FAO: Planning Department,
Welwyn Hatfield Borough Council

Ref: 6/2022/2823/HOUSE
Date: 16/01/2023

HISTORIC BUILDINGS AND CONSERVATION ADVICE

RE: 1 Lysley Place, Brookmans Park, AL9 6NZ

Roof Plan 1:200

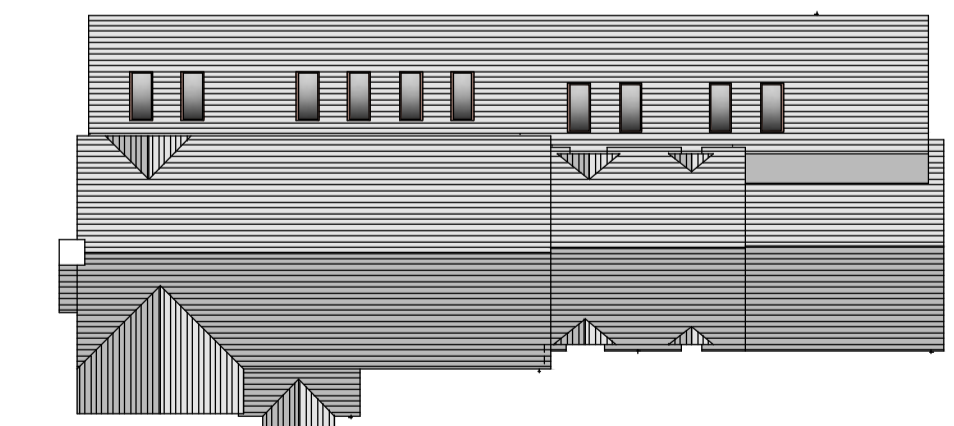
There is, however, a preference for the clay plain tiles to be retained or for natural slates to be used as these create a more sympathetic and traditional roofscape adjacent to the listed buildings than the proposed grey plain tiles.
